Construction Noise and Vibration review for SSD-30759158

Construction Noise And Vibration Report-- Day Design

I refer to Report 7280 – 1.3R Construction Noise & Vibration Dated 14th April 2022 Prepared by Day Design Pty Ltd: I have little experience in building and construction projects but have considerable experience with regard to trucks and transport equipment and mining logistics.

Located at 268 Catherine Fields Rd, Catherine Fields, NSW

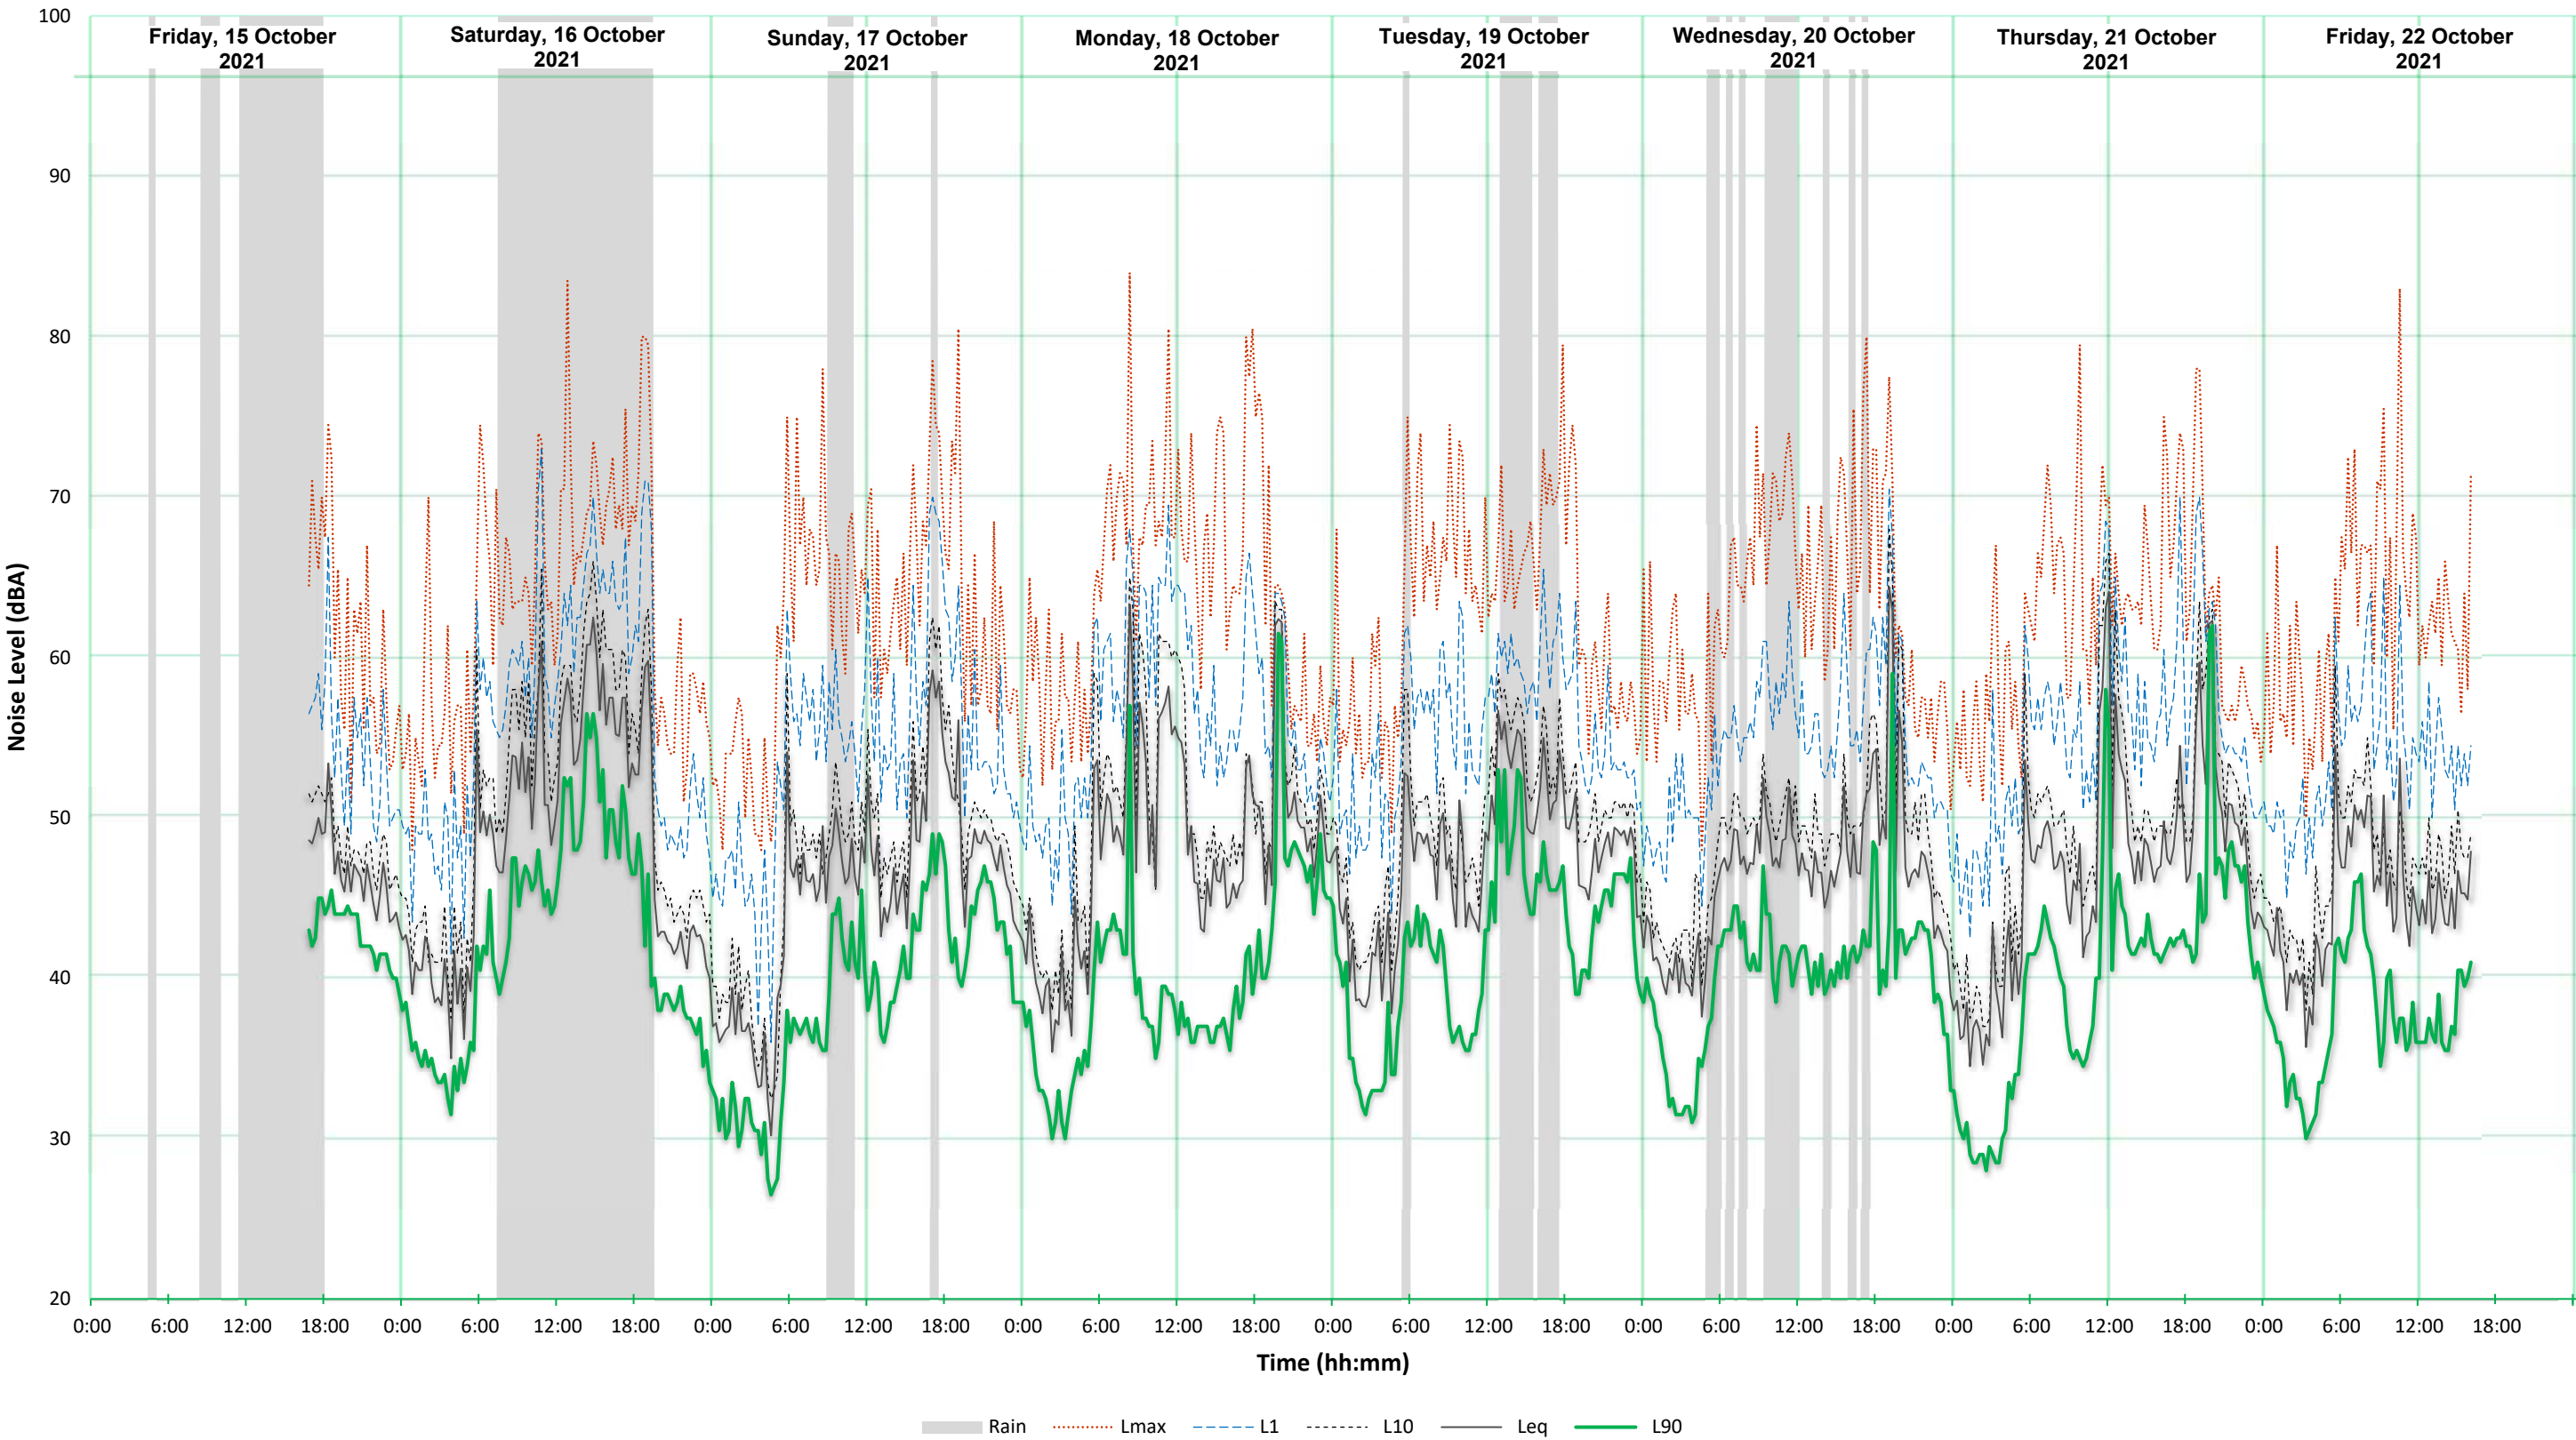
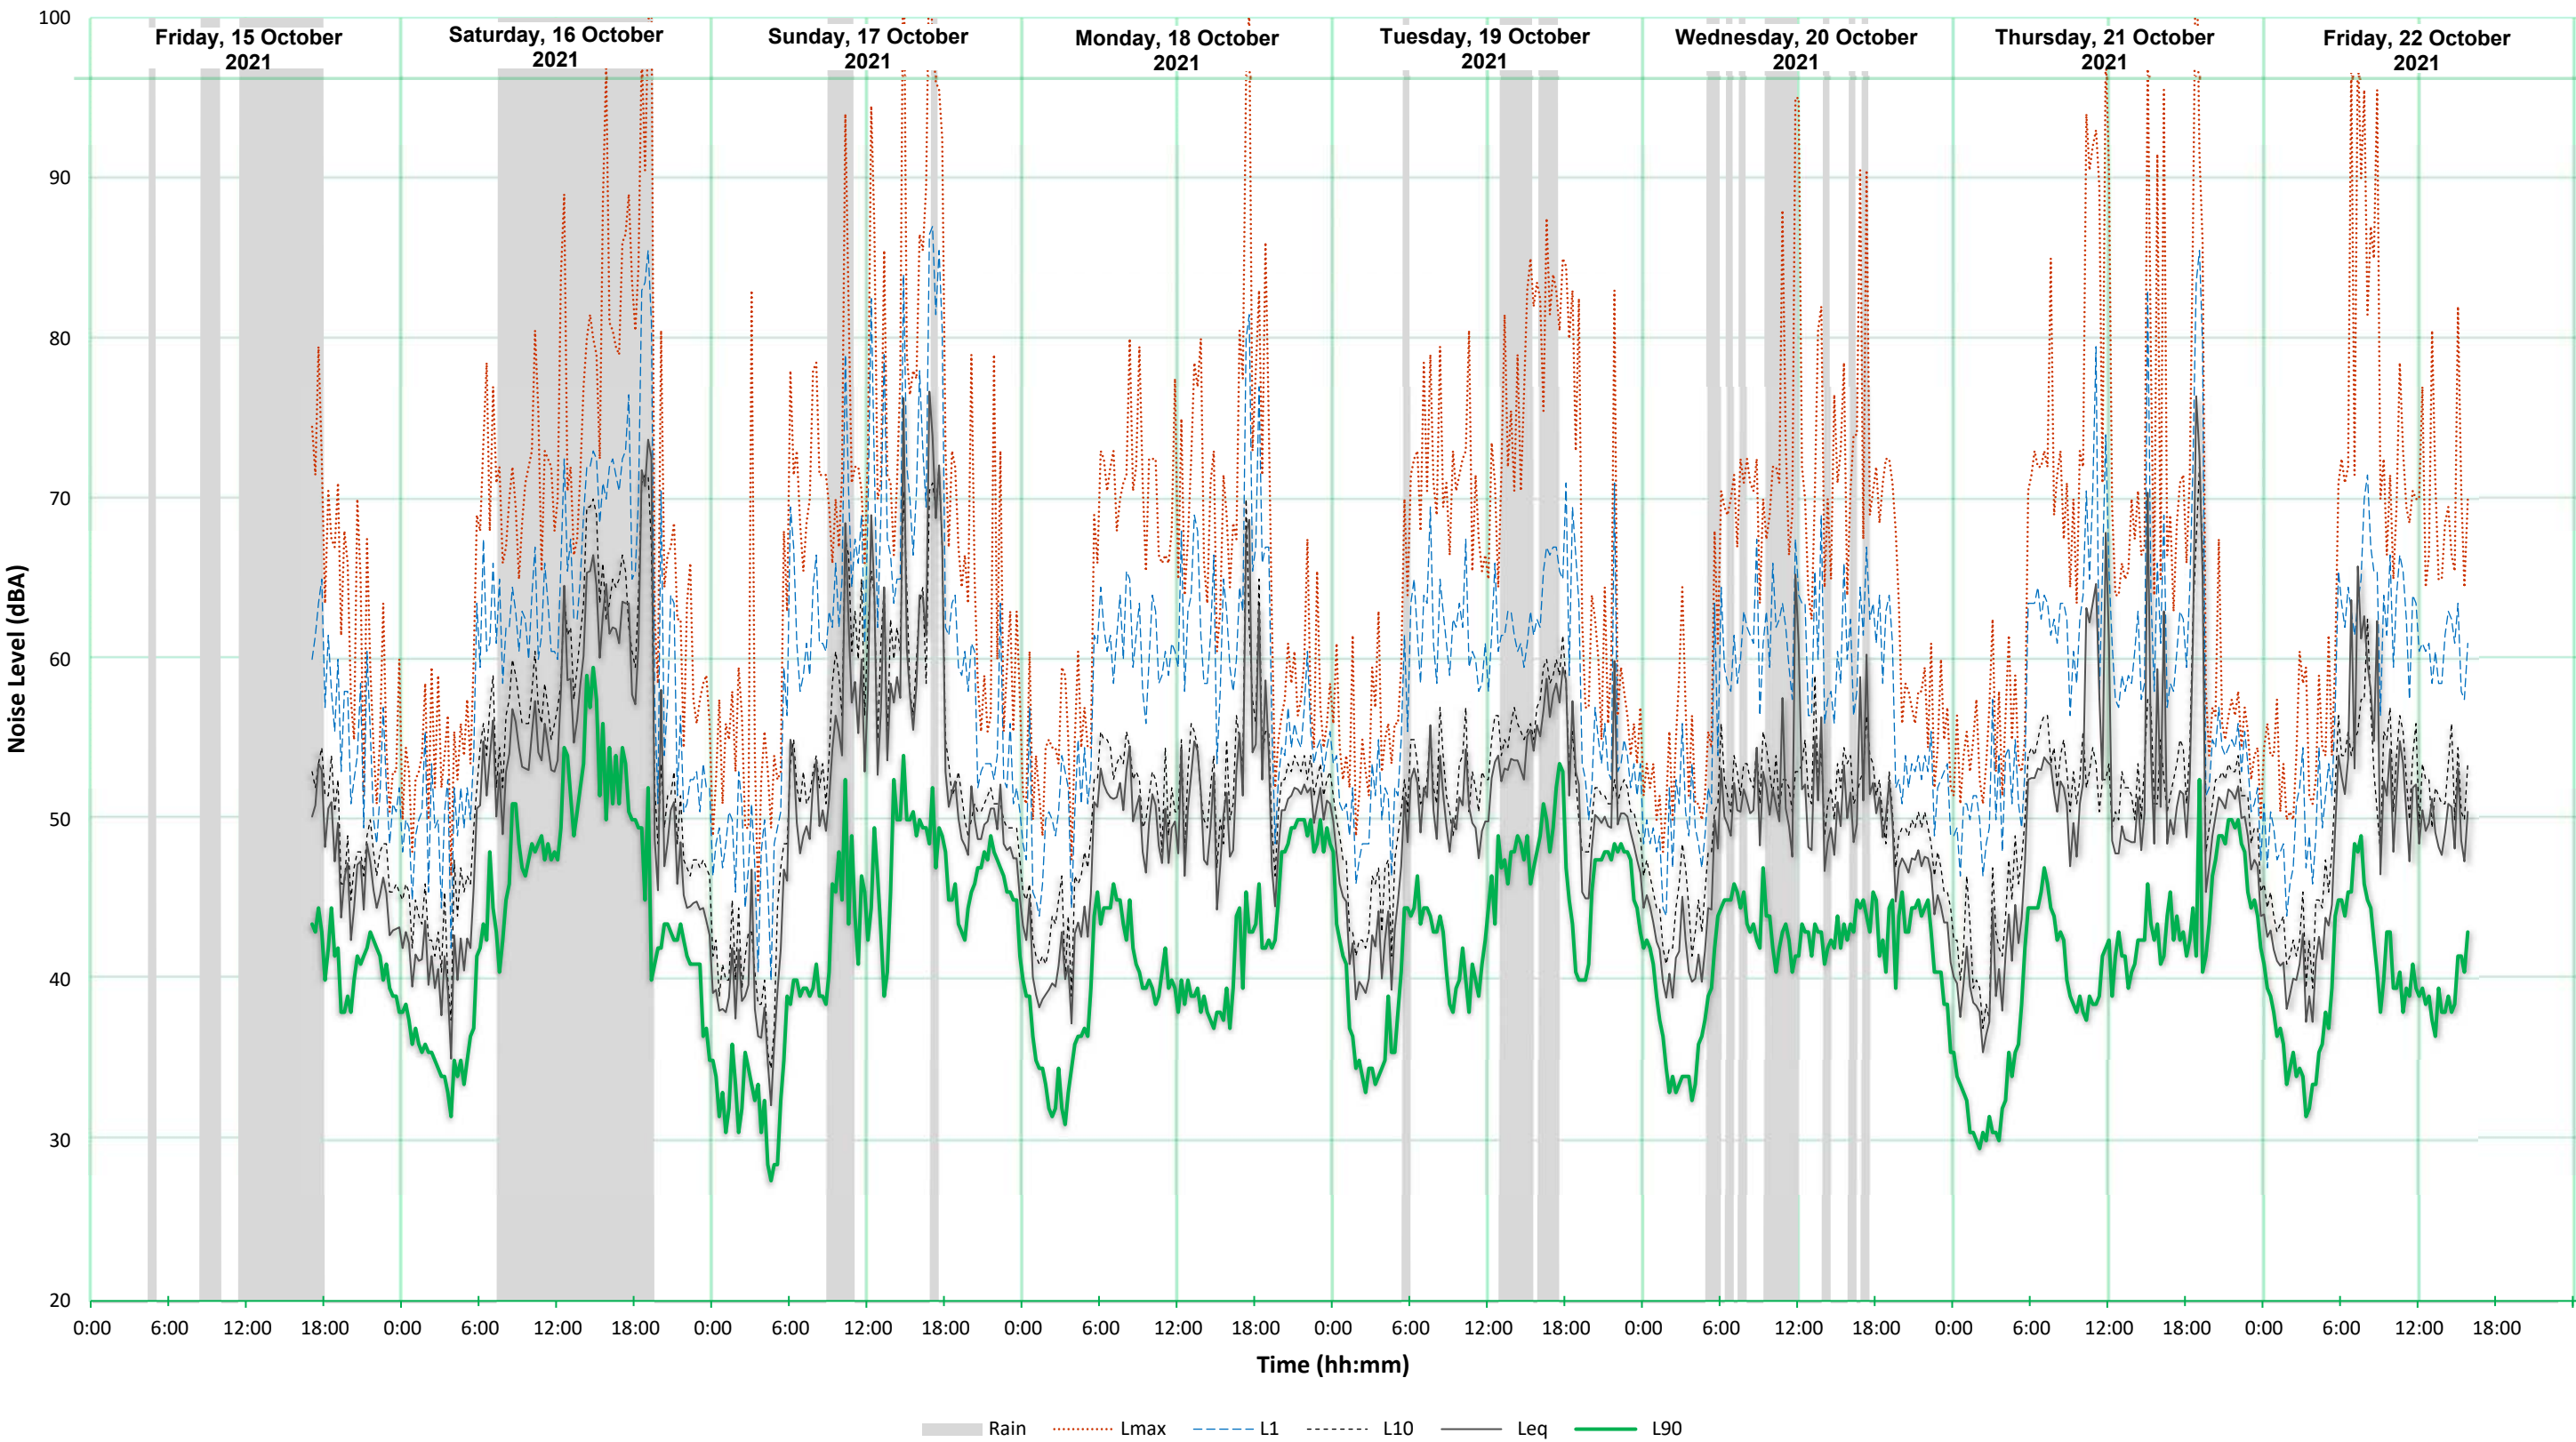
I note at the bottom of P13, 5.1 there is a reference to the data logger in position A being stolen and never recovered containing data between Wednesday 25th August and 2nd September.

Table 3 on p14 shows results for that same period. One of these statements must therefore be false and misleading. How can you show data that you supposedly don’t have?

I also note that there is data in Table 3 purporting to be between 15th September and 22nd September but there is no supporting data in Appendices B1, B2, B3, B4 for these dates also.

At the bottom of p14 referring to Table 3 a statement about meteorological conditions appears contradictory as it talks about “where applicable rain or wind affected data has been removed from the assessment period” Given that the data in Appendices B1-B4 has a mixture of rain affected days and clear days it is confusing at best. Dates not covered in Table 3 also have a mixture of wet and dry days causing one to wonder if the dates used have been cherry picked to achieve a specific set of numbers?
